## Application for a Non-Material Amendment Following a Grant of Planning Permission

Single storey kitchen pitched roof with exposed kitchen extract to be removed, and new brickwork wall with timber windows and parapet upstand to conceal flat roof over installed to match in with existing elevation

CURRENT APPROVED
PROPOSED GROUND FLOOR LAYOUT
SCALE 1:100

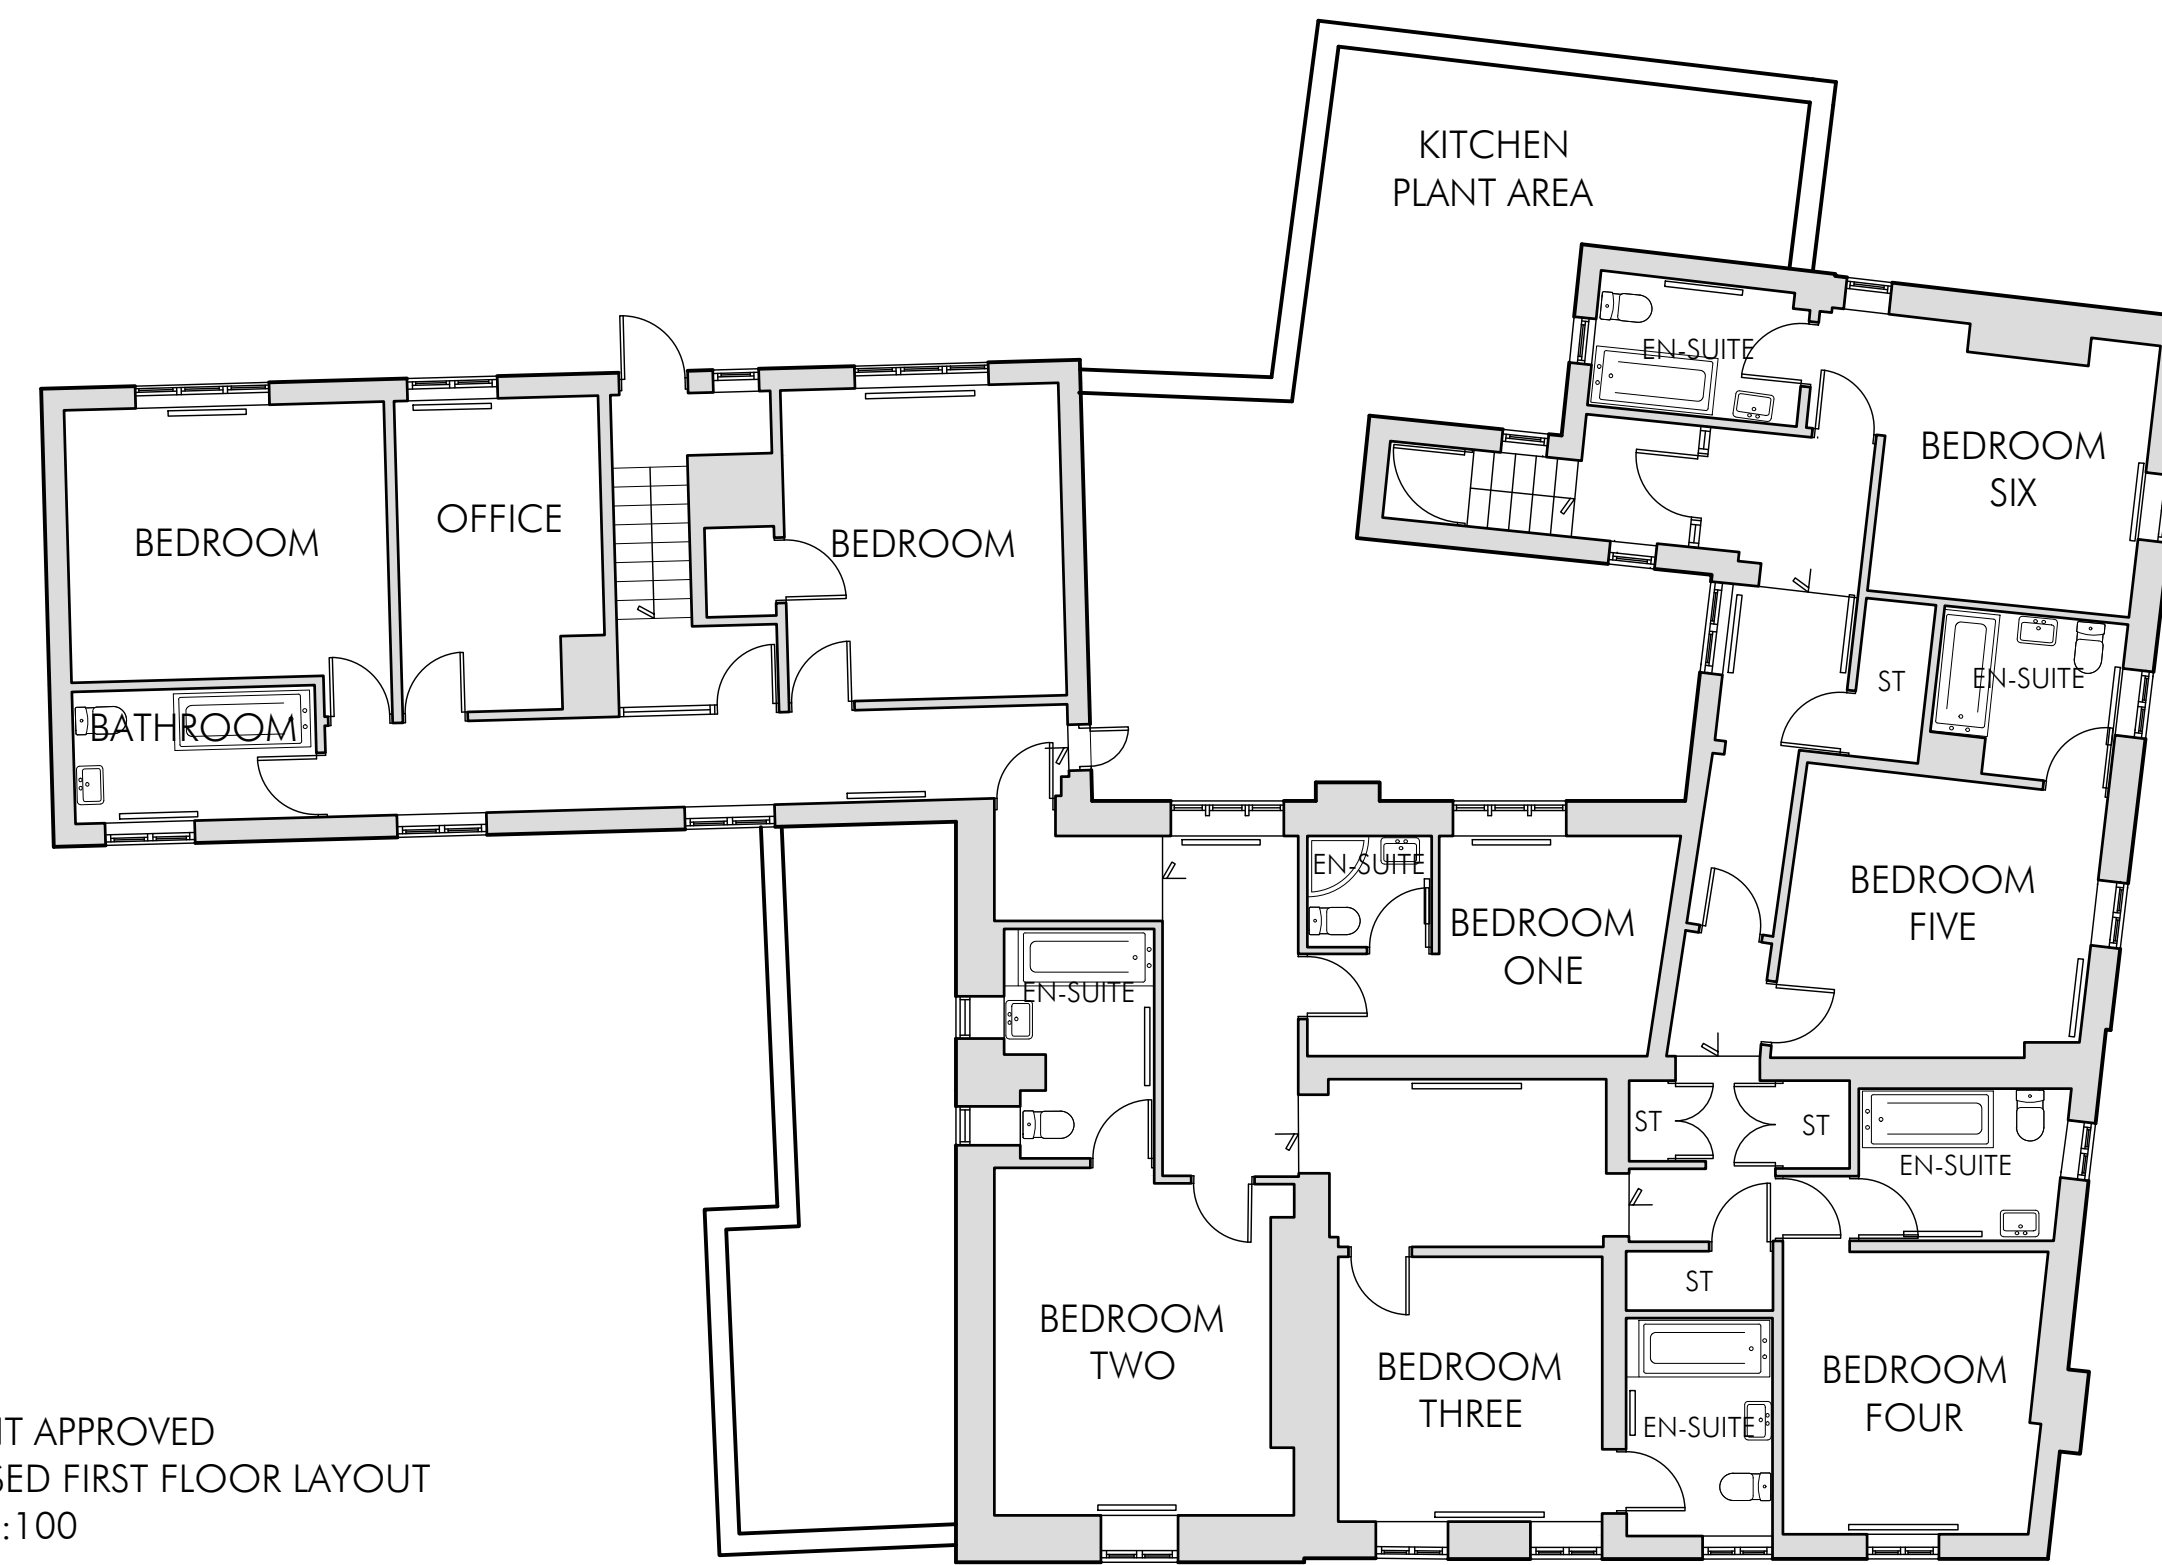
1no Door was removed from Side Elevation,  
2no windows removed from the Rear Elevation  
1no Door opening added to the Rear Elevation

To allow ramped access from the carpark into the public house
